From: Amanda Scholes on behalf of Planning.Responses
Sent: 03 November 2021 08:32
To: Planning Scanning
Subject: FW: Planning Consultation on: BE/121/21/RES
Attachments: 1744-U03-P06-B.PDF; 1744-U03-P01-B.PDF; 1744-U03-P02-B.PDF; 1744-U03-P03-B.PDF; XXX-HYD-PH3-ZZ-DR-C-7010_P04.pdf; 5920.PP_U3.1.0B.PDF

Application No: BE/121/21/RES

Site Address: Unit 3 Land At Salt Box West of Shripney Road Bognor Regis PO22 9NW

Description of Works: Approval of reserved matters following BE/135/18/PL for appearance, landscaping and layout of Unit 3. This application may affect the character & appearance of the Shripney Conservation Area & is in CIL Zone 2 (Zero Rated) as other development.

HYDROCK PROJECT NO. C-13319-C	SCALE @ A1 1:250
STATUS DESCRIPTION TENDER	STATUS D2
DRAWING NO. (PROJECT CODE-ORIGINATOR-ZONE-LEVEL-TYPE-ROLE-NUMBER) SAL-HYD-PH3-ZZ-DR-C-7010	REVISION P04

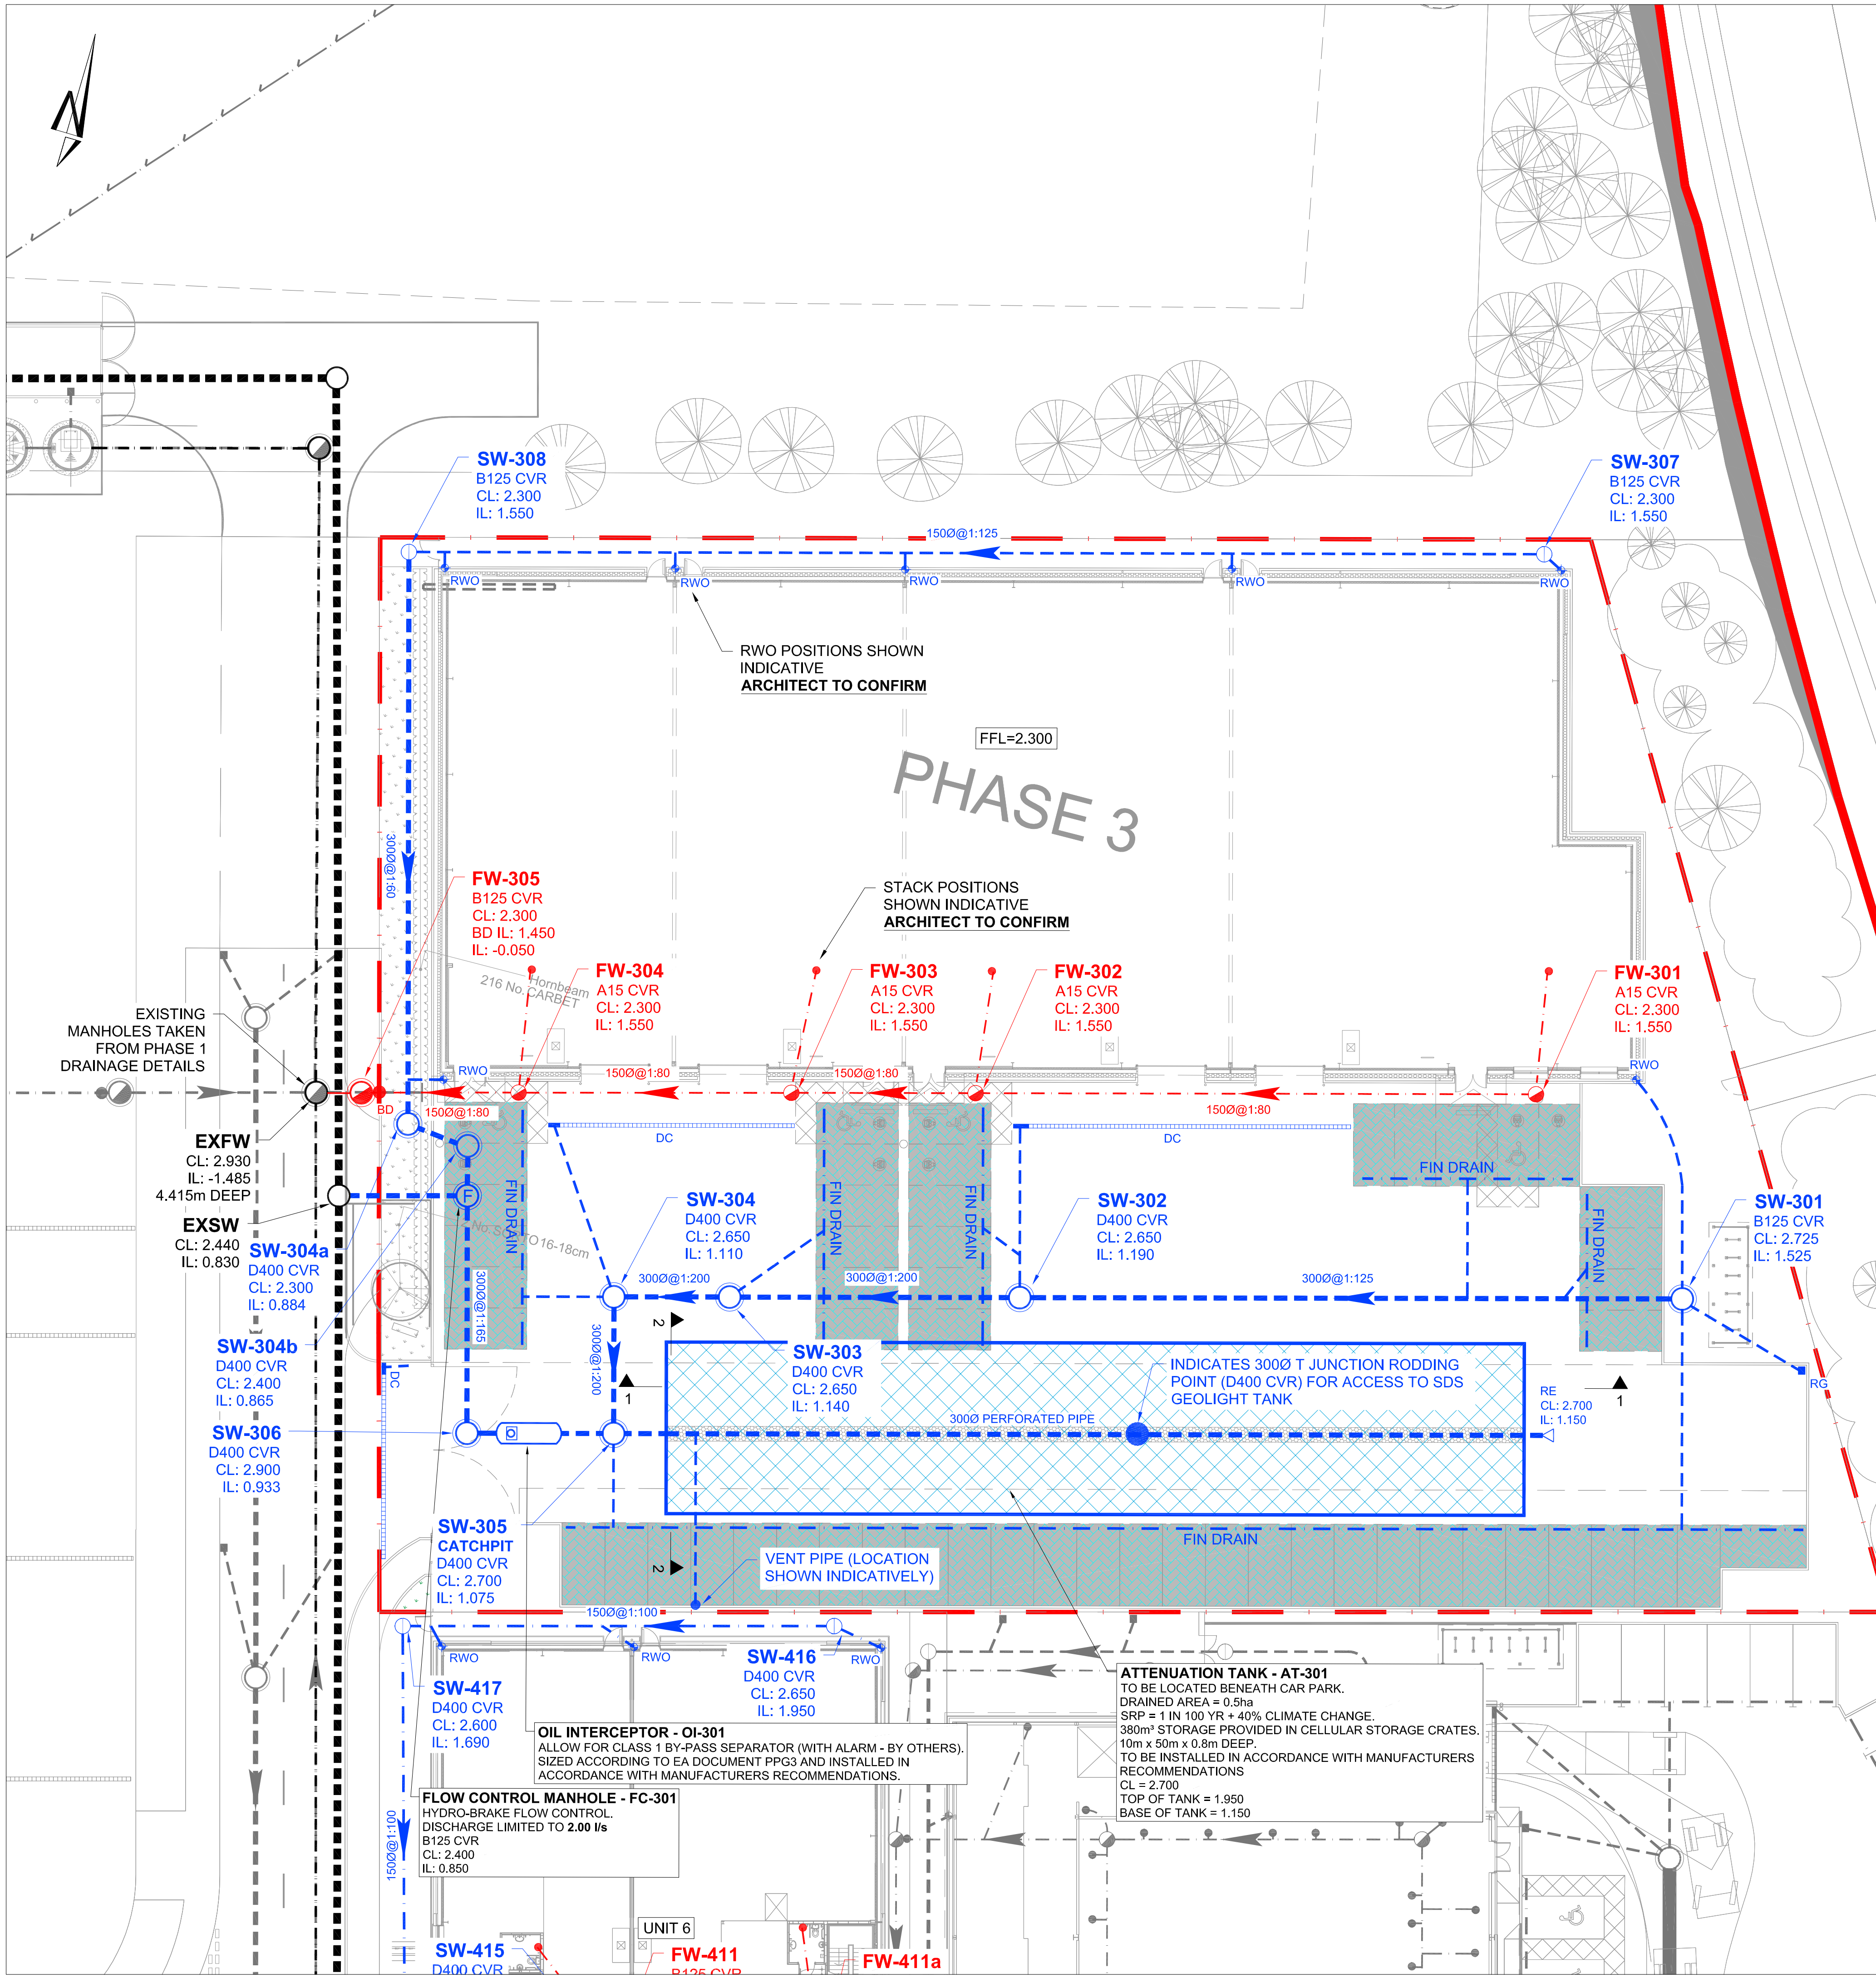
We note that two trees are proposed along the line of the surface water drainage network. Trees must not be planted directly over pipelines and should be positioned so that their root potential areas do not overlap with surface water drainage features. The tree roots will likely damage the pipeline and result in failure of the network, we therefore object to the proposals as they currently stand. Please can a revised landscaping plan be submitted which evidences that proposed trees will not detrimentally impact the drainage.

Michael,
Attached are updated architectural, civils and landscape plans with the northern of the 2 trees removed, which hopefully solves the issue.
I presume with this resolved there is nothing stopping the approval of the RMA?
Kind regards

Proposed site plan

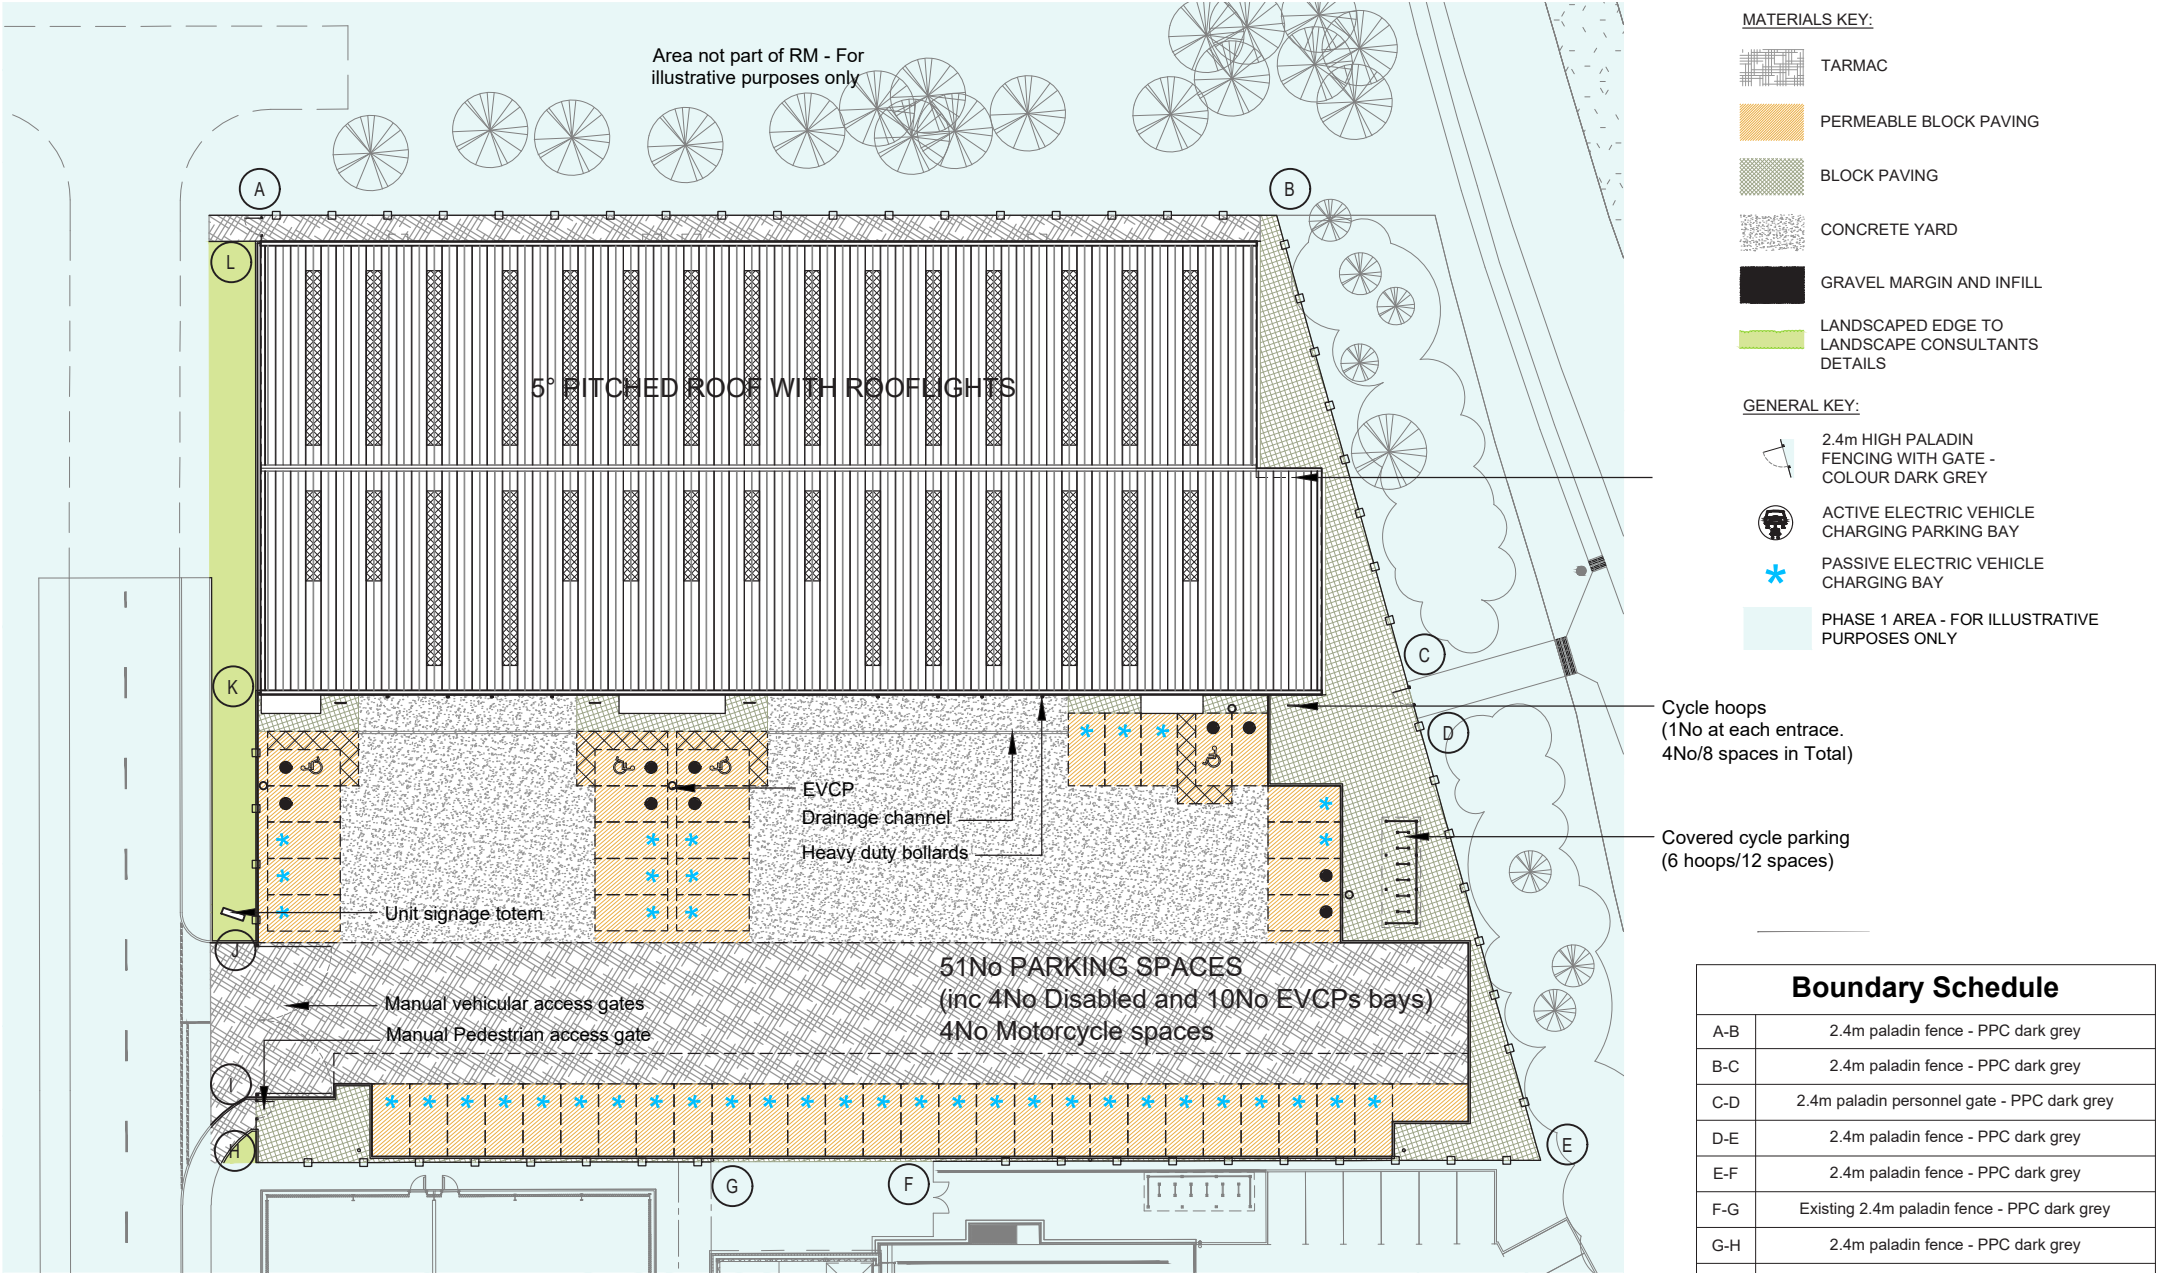
I have reviewed the attached information and drawing amends, particularly Dwg no 5920.PP_U3.1.0 Rev B.

I conclude that I would have **no objection** to the revised proposals to remove 1no Sorbus tree and to the repositioning of the remaining in order to facilitate and design out drainage conflict. The remaining tree will be able to establish without adjacent competition and with time will achieve an established specimen on this location.
